To summarise, we have had to object to the proposal as it stands - the private package plant for disposing of foul sewage has been located on top of/ in close proximity to an existing water main that lies within the site and is covered by a legal easement.

Jenny Quinn
Planning Manager
Planning, Landscape and Ecology
M: 07776 105657 (mobex 55657)
unitedutilities.com

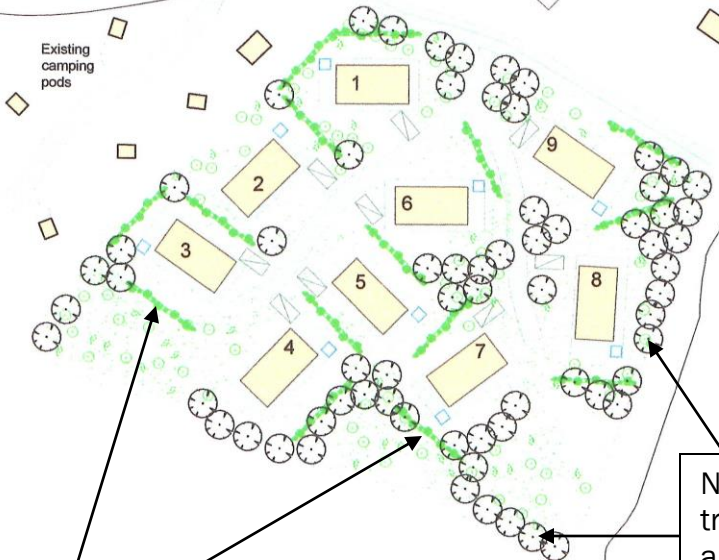
We have advised the applicant to use our free of charge pre-development service to contact Water Developer Services as a matter of urgency in order to discuss the location of this main and their options for the relocating the package plant. Once this has taken place and a revised layout plan has been assessed by UU then we may be in a position to remove this objection.
